REPORT UPDATE

Application No: BR/244/10/

LOCATION: 36-38 Sudley Road
Bognor Regis

PROPOSAL: Proposed single storey extension.

Proposed South West Elevation
Scale 1:100

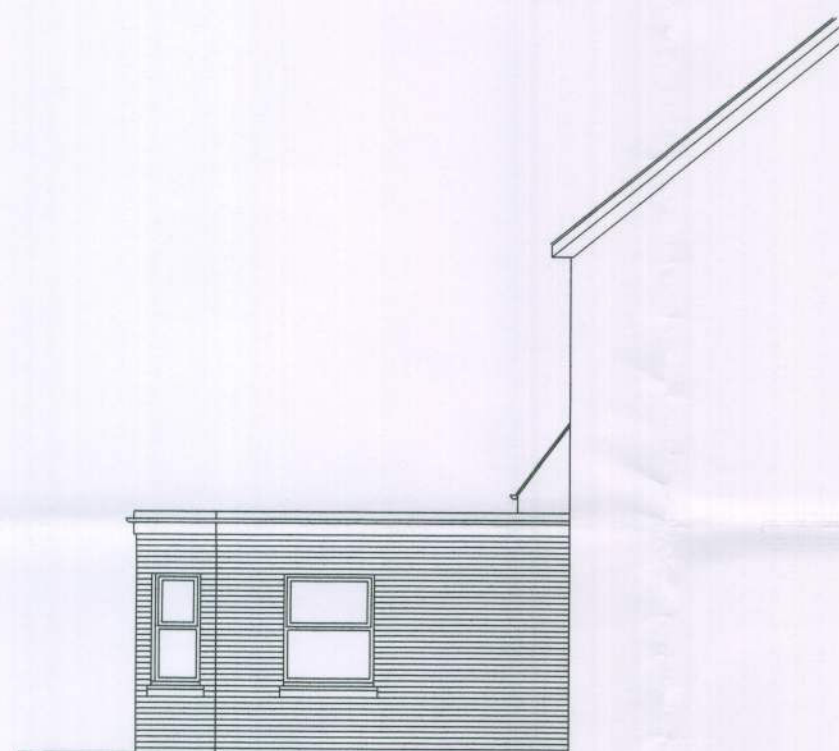
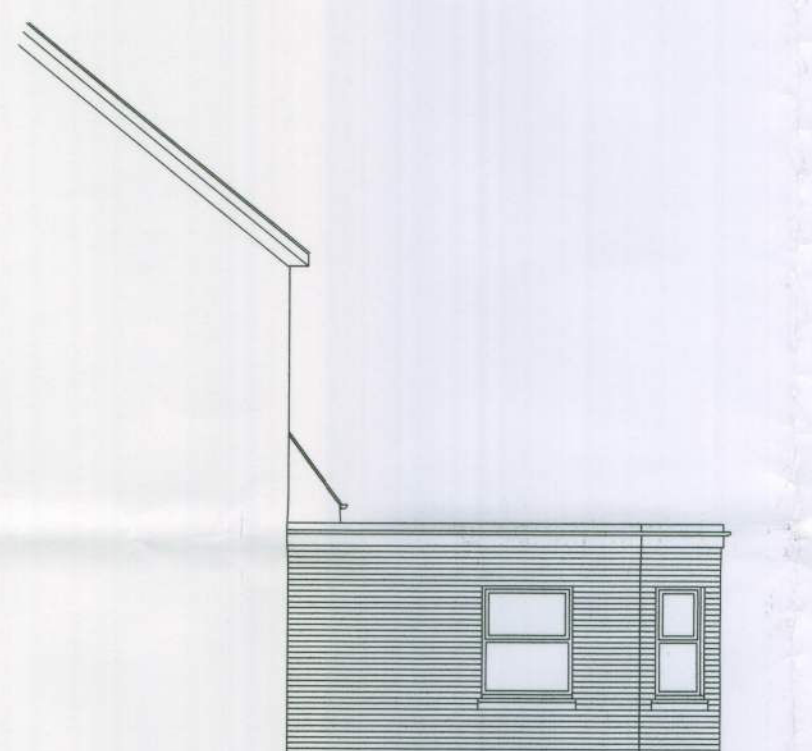
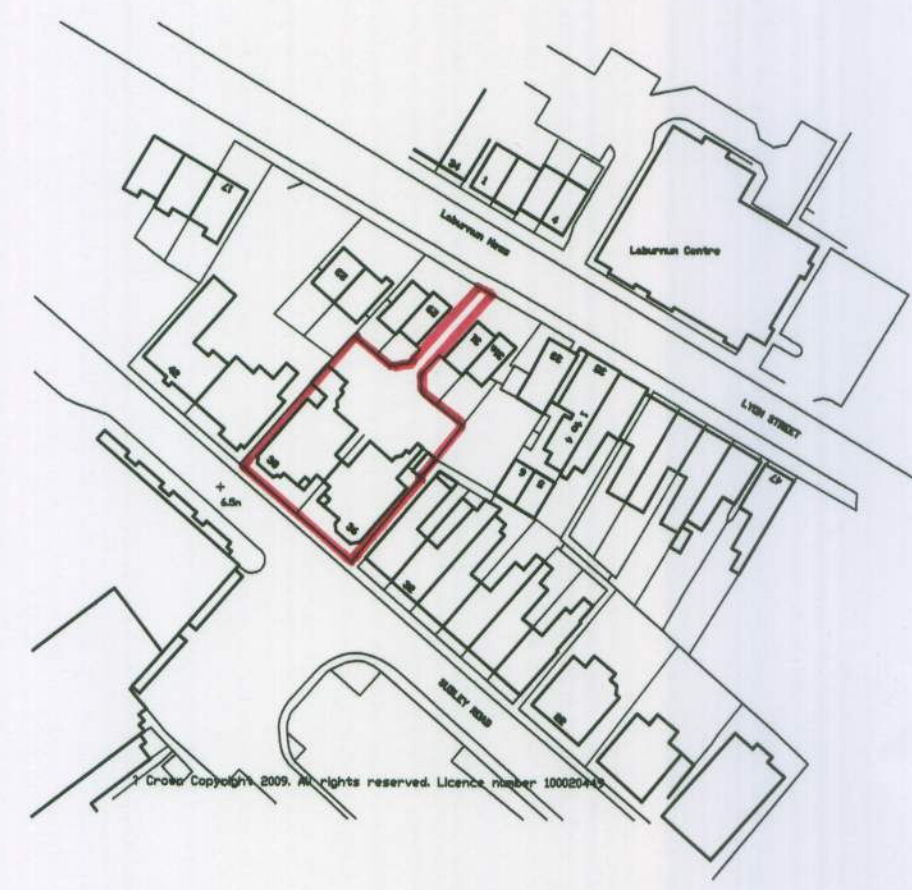
Objection on the grounds this is out of character with the street scene.

It is not considered that the extension would be out of character with the street scene.

BLOCK PLAN
Scale 1:500

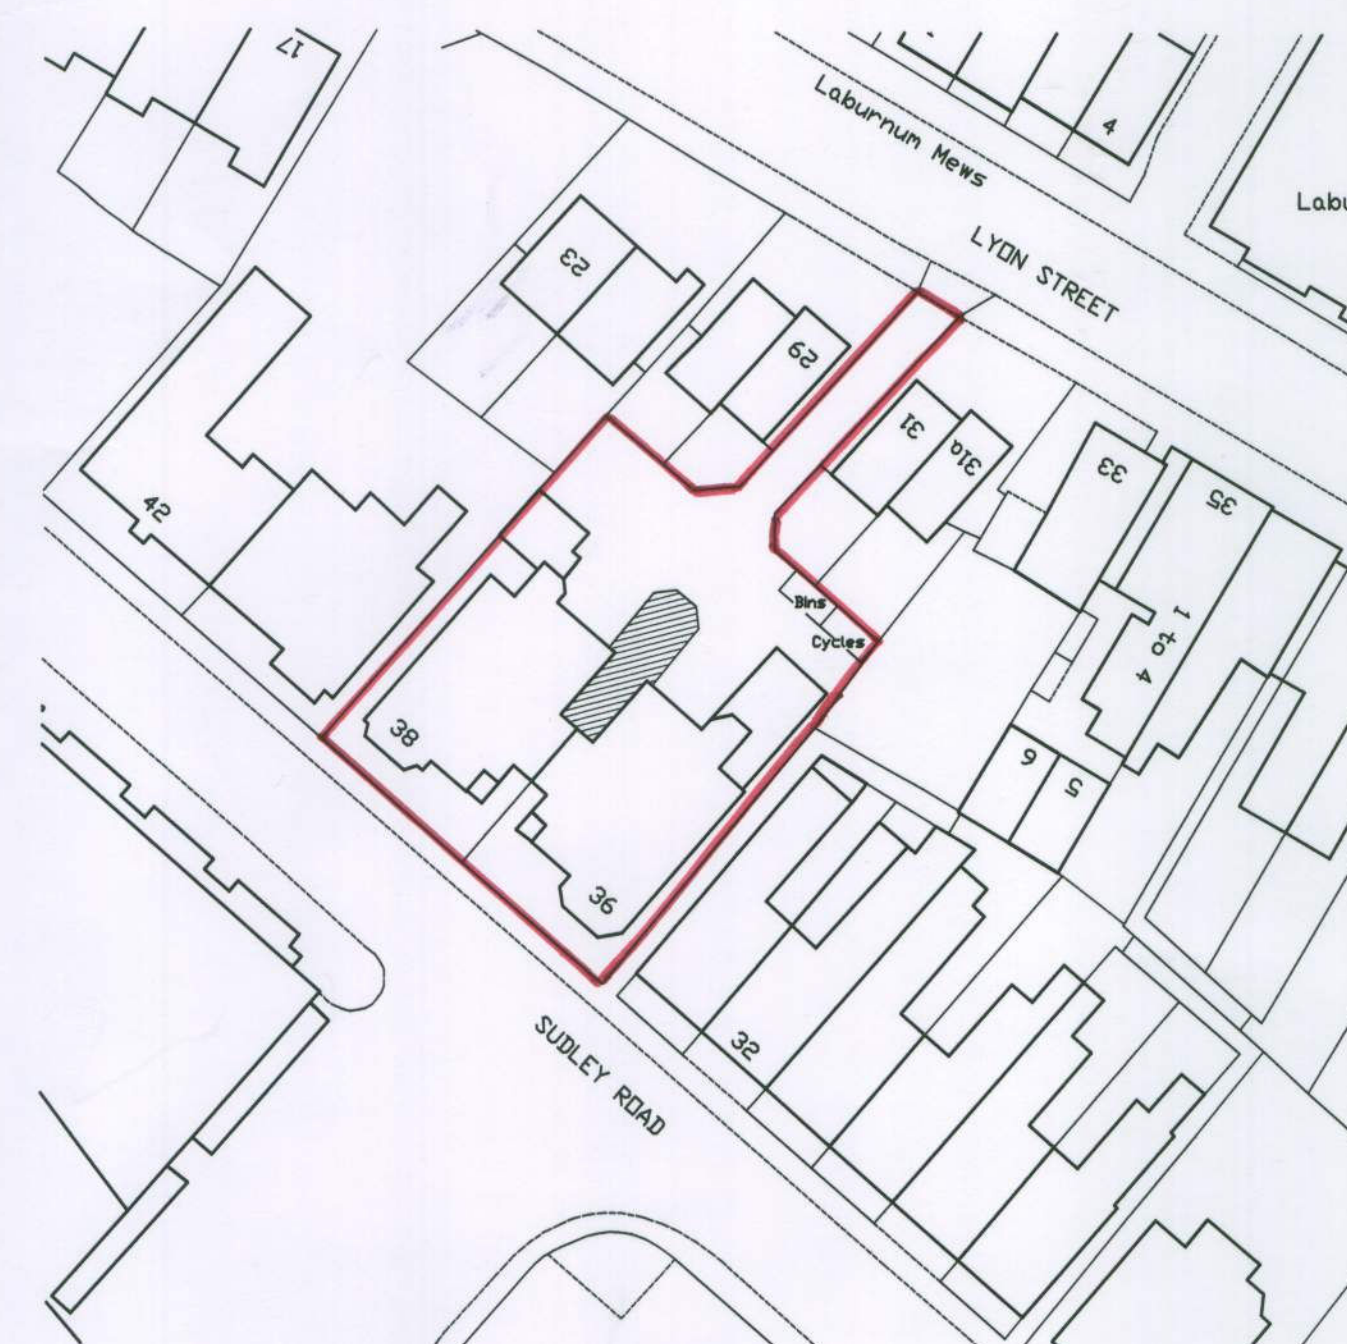
It appears from the plan that the extension may result in the loss of an off-street parking space within the site. However, in terms of transport the property is situated in a sustainable location. The property is within walking distance of a range of services and public transport, hence there is no reliance as such on the use of the private car. Secure and covered cycle parking should be available for staff as well as residents and visitors.

If the LPA are minded to approve this application, a condition securing cycle parking should be included.

An area for cycles is to be provided as part of the overall proposals for the site.

Proposed Ground Floor
Scale 1:100

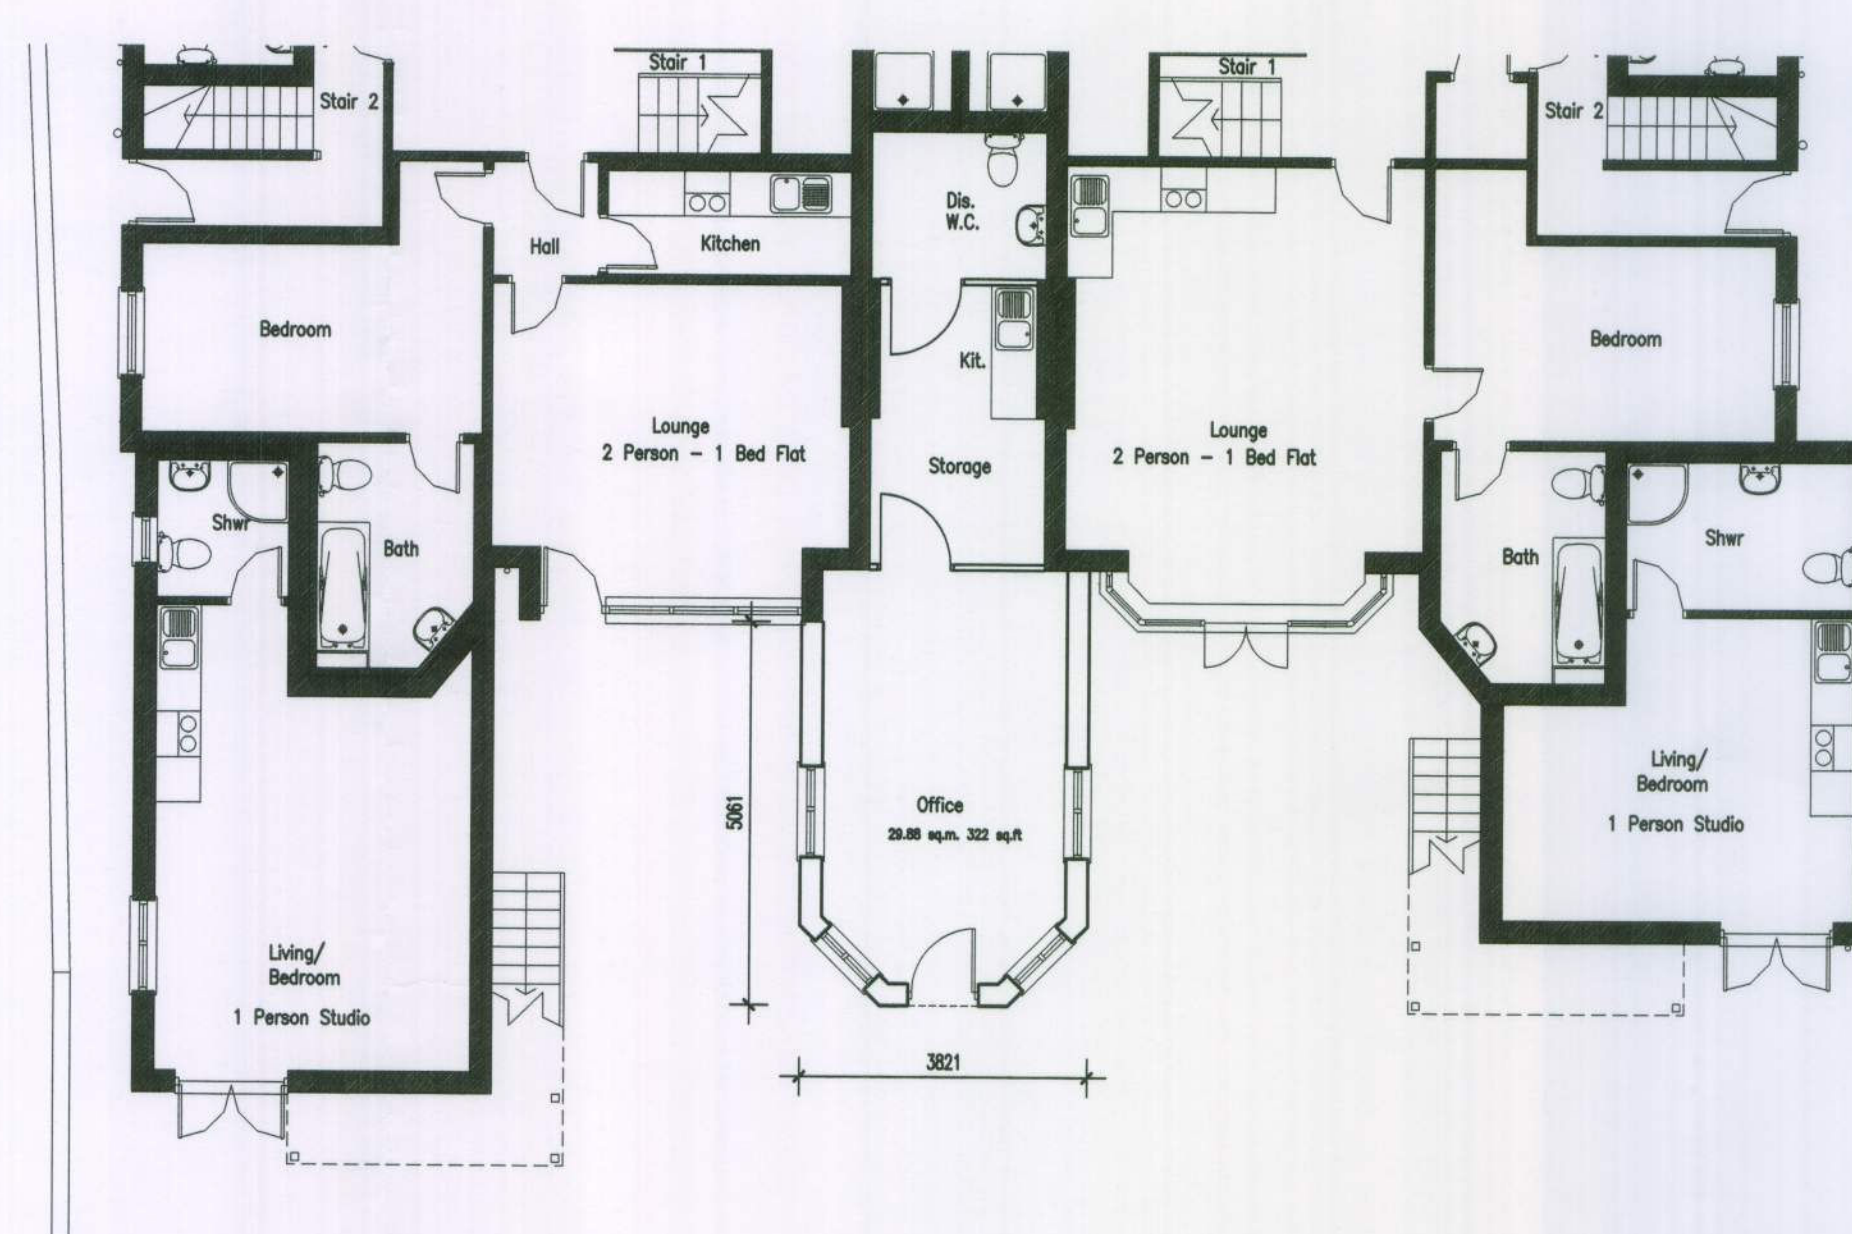
It the accommodation is to be used solely for office accommodation and storage then the kitchen and toilet areas are to be adequately lit and ventilated.

However, with the facilities provided as shown on the drawings it is feasible that the development could be used as residential accommodation and if so the following comments are offered.

There is inadequate natural lighting and ventilation to the kitchen area:

a. there should be natural lighting provided by glazed windows with an area equivalent to 1/10th of the floor area.

b. there should be natural ventilation provided by means of openable windows where the area of the openable parts is equivalent to 1/20th of the floor area.

The applicant's agent has clearly stated that the extension is to be used as office accommodation and any permission can be so conditioned to that effect.
